Rustington Parish Council

Our Ref: CW/CH/JM/PLAN/21
Date: 11 June 2021

R/108/21/PL - Demolition of two dwellings and the construction of 3 No. 3-bed town houses and 7 flats. This site is in CIL Zone 4 and is CIL Liable as new dwellings - 117 Sea Lane, Rustington

DRAWING TITLE 3D Views

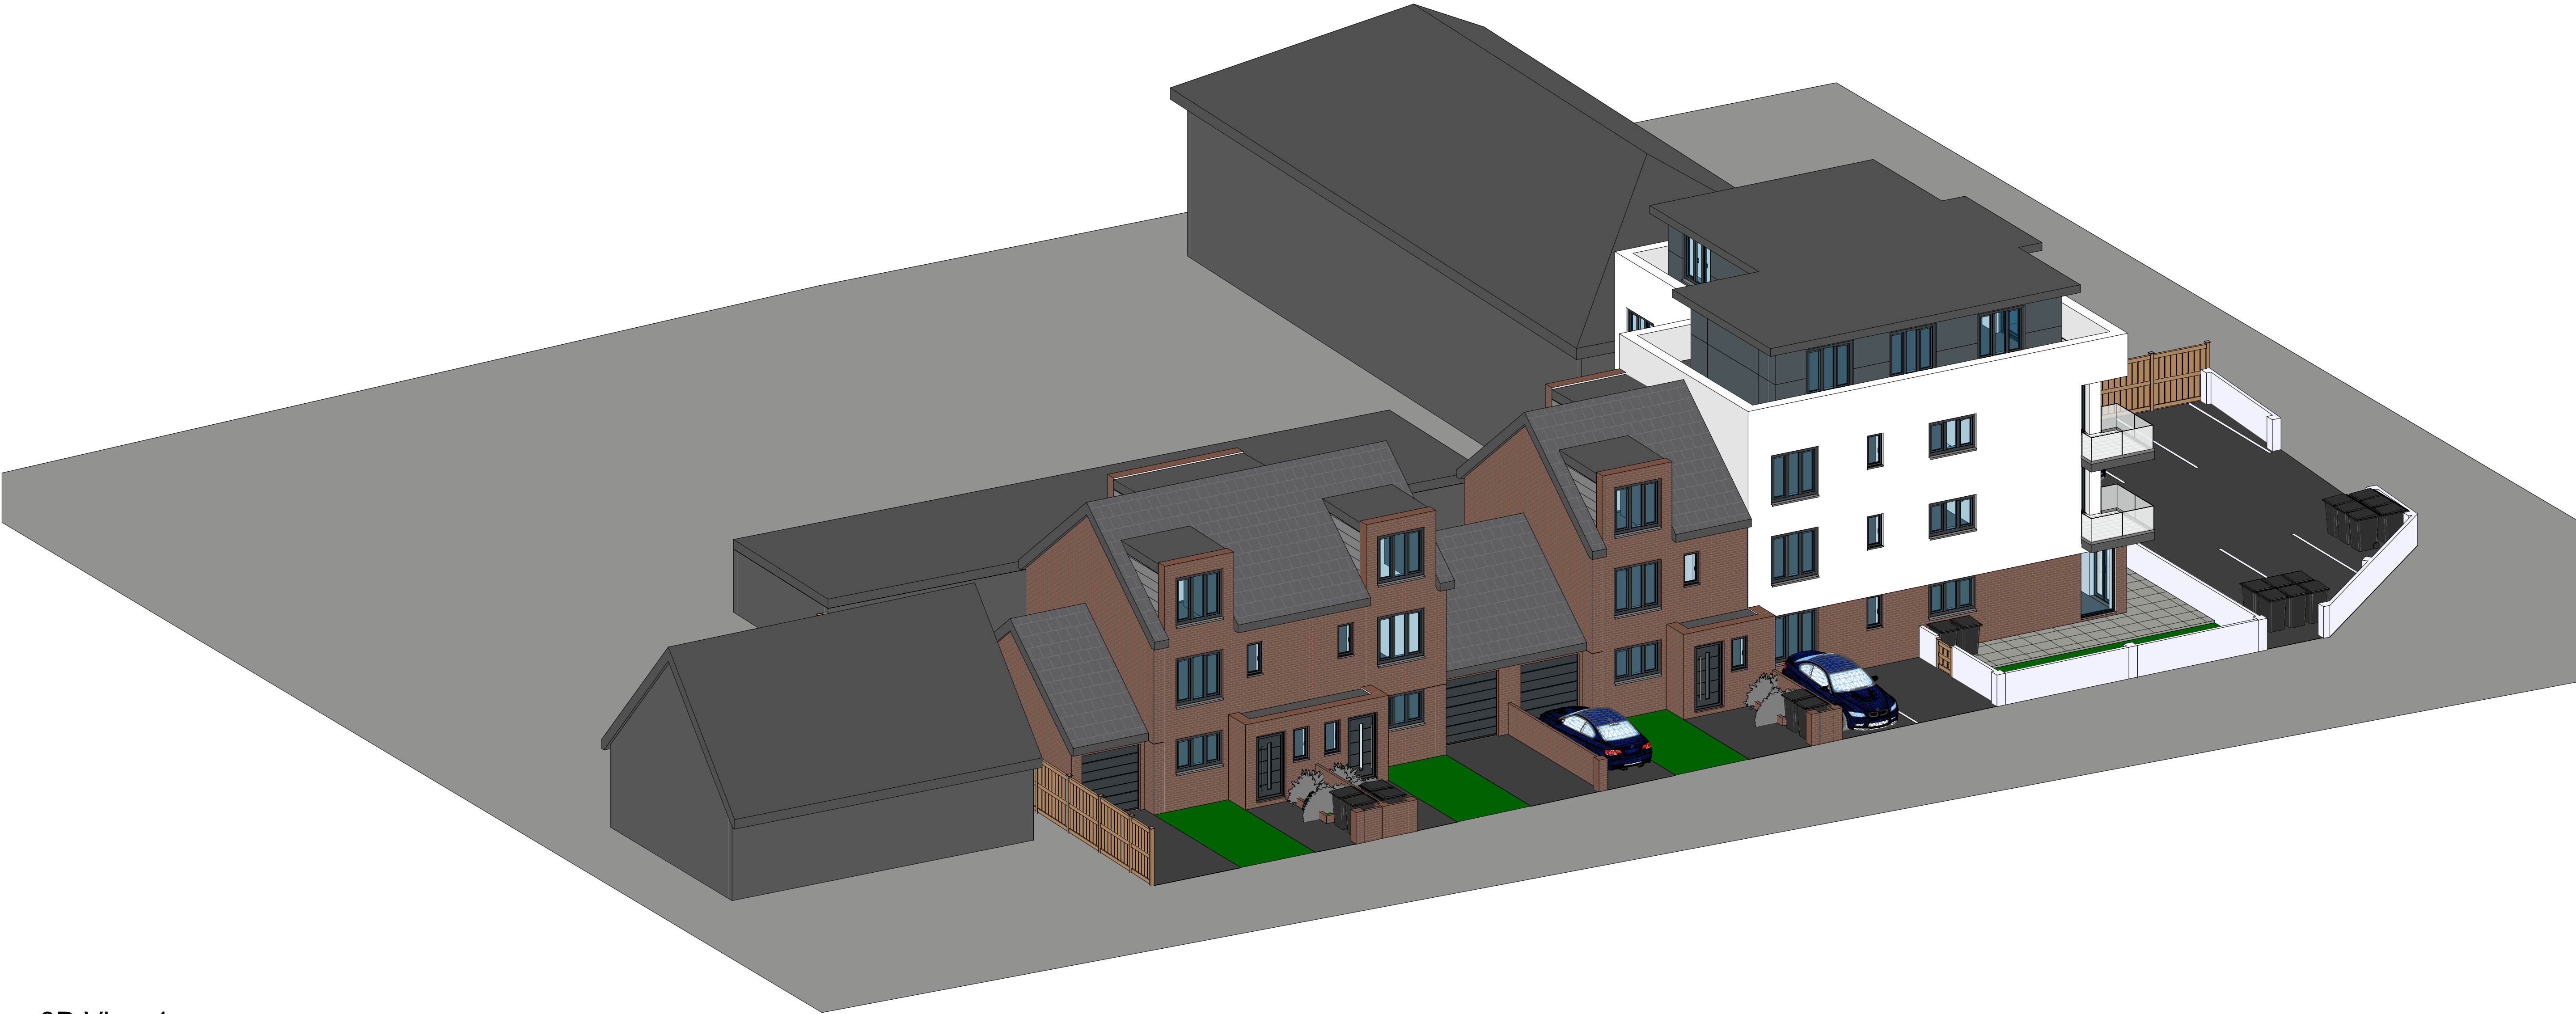
- (i) The proposal to develop this site by the erection of 3 No. 3-bed town houses and 7 flats would present an extreme over-dominant appearance and would have a damaging impact, by reason of their height, shape and mass, on the residential amenities of surrounding properties and the appearance of the street scene (In conflict with Arun District Local Plan Policy DSP1)

A REV	27/10/21 DATE	Second floor removed. DESCRIPTION	18th Mar 2021		EL	
			DRAWING TITLE PROPOSED STREET ELEVATIONS 1			
			SCALE 1 : 100@ A1		DRAWING NO. P202

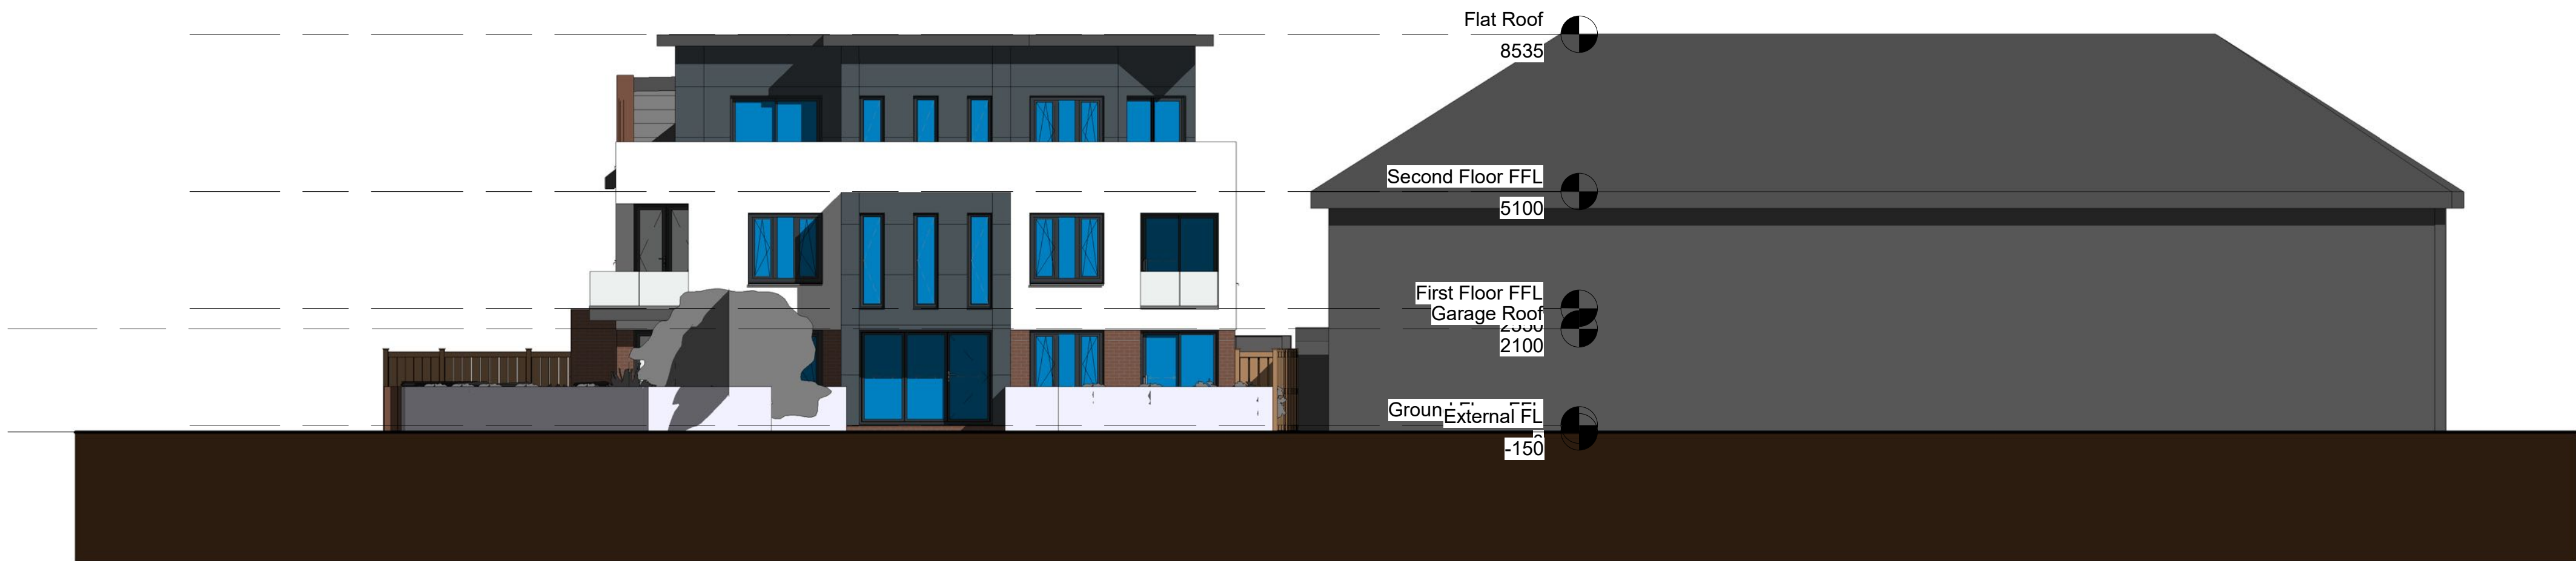
- (ii) The proposal, which would be higher than that of the adjacent flats and No. 2 Shaftesbury Road, would present an over-bearing and unsympathetic appearance for the occupiers of these properties, in particular, which would result in a loss of privacy by reason of overlooking and would, most certainly, adversely affect the quiet enjoyment of the occupiers of the aforementioned properties

- (ix) The proposal is in conflict with the Rustington Neighbourhood Plan (Policy 2: Housing Design) on many counts
- (x) The design of the flats with a flat roof is totally out of keeping architecturally with all of the other properties in the immediate area which have pitched roofs
